City of Albuquerque Stormwater Construction Site Inspection Report

ESC File No.	H15E007	Project Name:	Galles Chevrolet Parking Lot		
NPDES Id. No.	NMR1005MK	Location:	2001 Candelaria Rd. NE		
2/12/2024	Lessee	Lessor			
Operator	Galles Chevrolet Inc.	SAI Inc.			
Contact name & title	Jamie Galles	Raul Modi			
e-mail	jamiegalles@galles.com	saiinc1@yahoo.com			
Contact Phone #	505-506-9531	505-803-6544			
COA Inspector	James Hughes	Start/End Time:	12:30pm		
Construction Phase:	Bare dirt no construction activity				
Type of Inspection:	Regular	Storm Event	Post Storm Event >0.25"	311/Complaint	Follow Up
Weather at time of inspection?	Clear		Temperature: ~	55	
Estimated date of last storm 0.25" or greater	1/4/2024

INTERIM GRADING & DRAINAGE PLAN

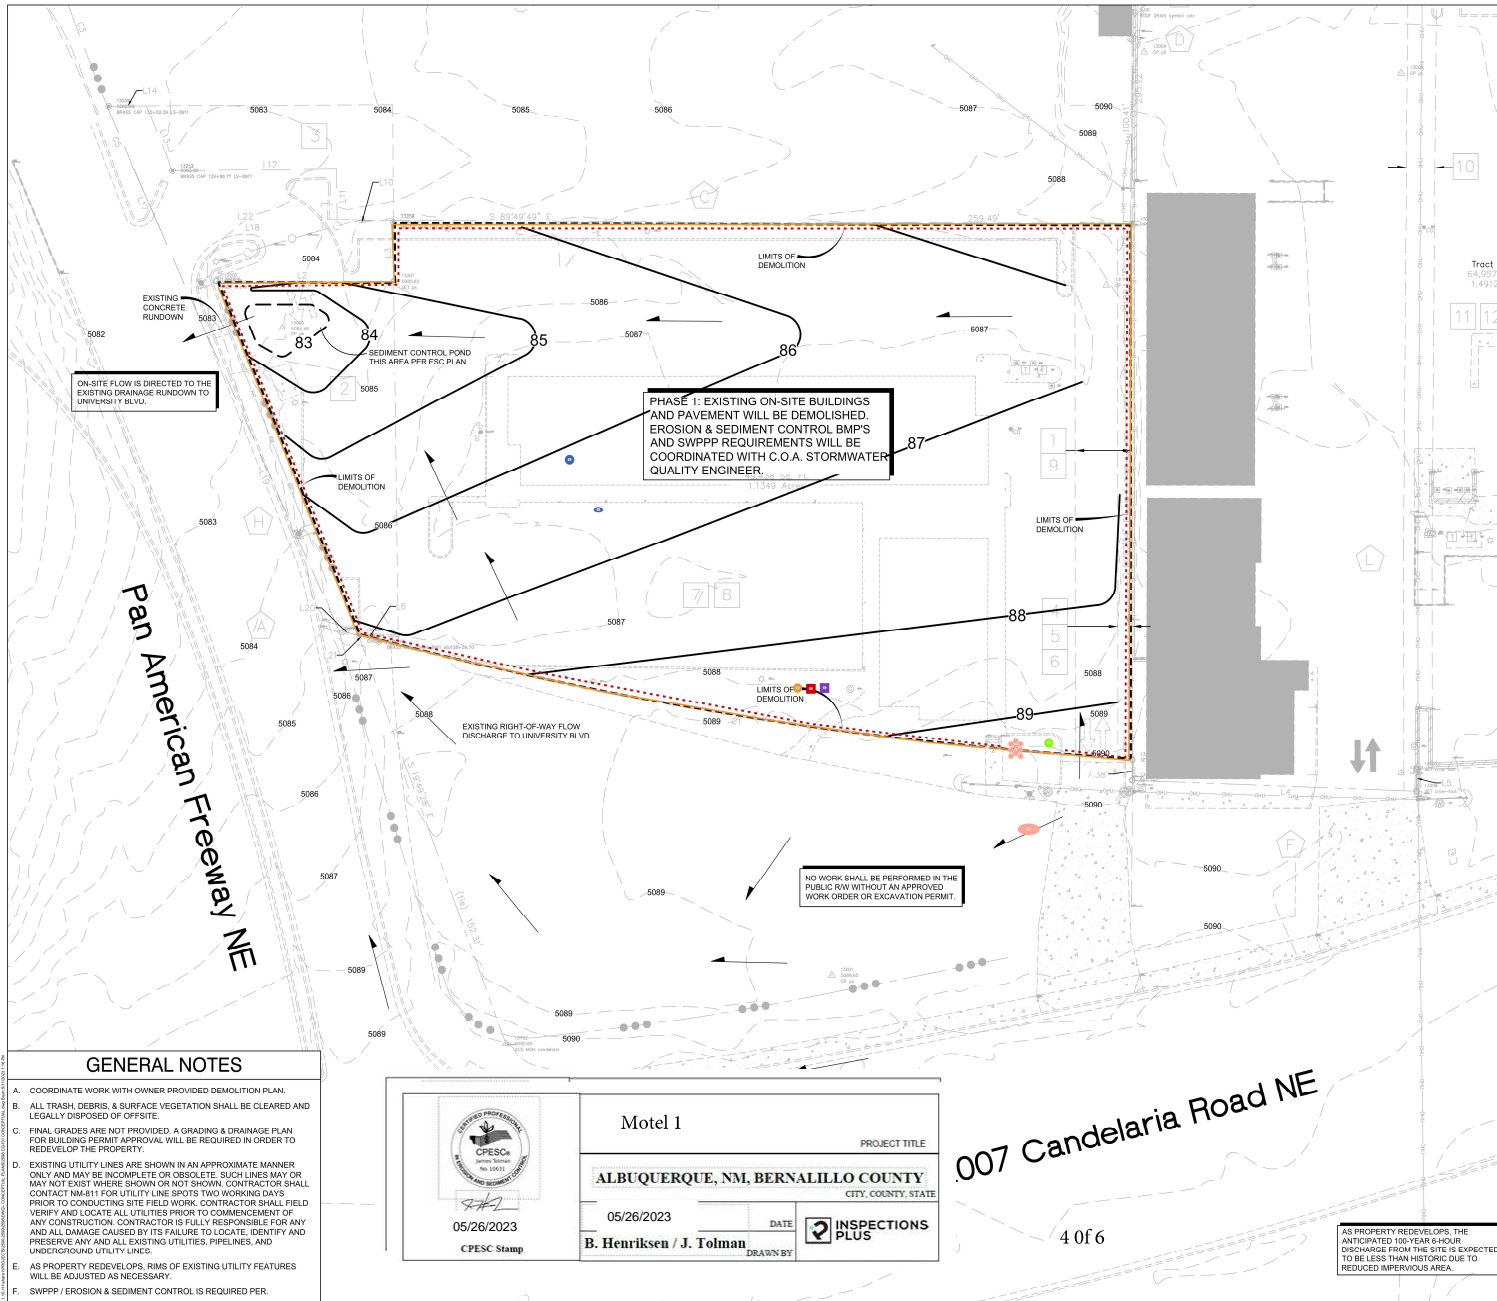
3	BMPs - The silt fence (SF) was missing and/or not embedded around most of the site in violation of CGP 2.2.3. Required Mitigation: You must Install sediment controls along any perimeter areas of the site that are downslope from any exposed soil or other disturbed areas, as required by CGP 2.2.3. When the problem requires a new or replacement control or significant repair, install the new or modified control and make it operational or complete it by no later than seven (7) calendar days from discovery per CGP 5.2.1.
4
